Subject: RE: Planning Consultation on: BR/77/22/PL

Engineers Comments Regarding Surface Water Drainage

Site Address: Rear of 42 Sudley Road Bognor Regis PO21 1ES

Description of Works: 2 No. semi-detached 3-storey houses with parking and new vehicular access.
This application is in CIL Zone 4 and is CIL liable as new dwellings.

SITE PLAN - 1/500

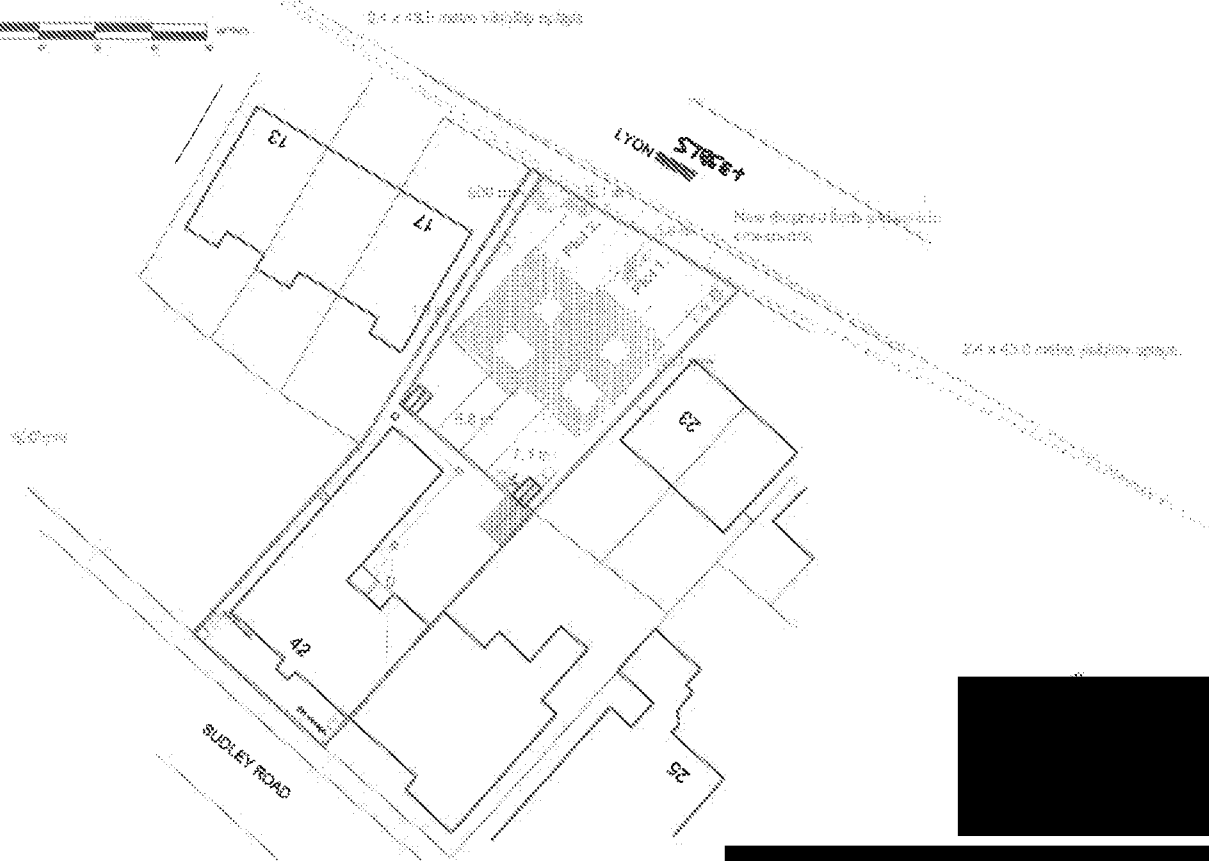
The proposed layout shows there is very limited space for surface water drainage, it appears that the proposals will not comply with West Sussex Lead Local Flood Authority Policy for the Management of Surface Water Policy 1. The supplied Drainage Statement even acknowledges that "There is no room to discharge the rainwater into soakaways

on the site". This is an acknowledgement that the proposed layout and density of development precludes the use of infiltration, rather than the ground conditions on the site.

To overcome my objection the applicant should complete winter groundwater monitoring and winter infiltration testing and complete calculations to assess the size of structures required. A rough plan should be formed showing where these structures can be provided within the proposed layout. Evidence that no pumping or ground raising would be also be required. Detailed design of the system can be left until discharge of conditions where the applicant should provide the level of information stated within our checklist [Drainage Planning Consultations | Arun District Council](#)
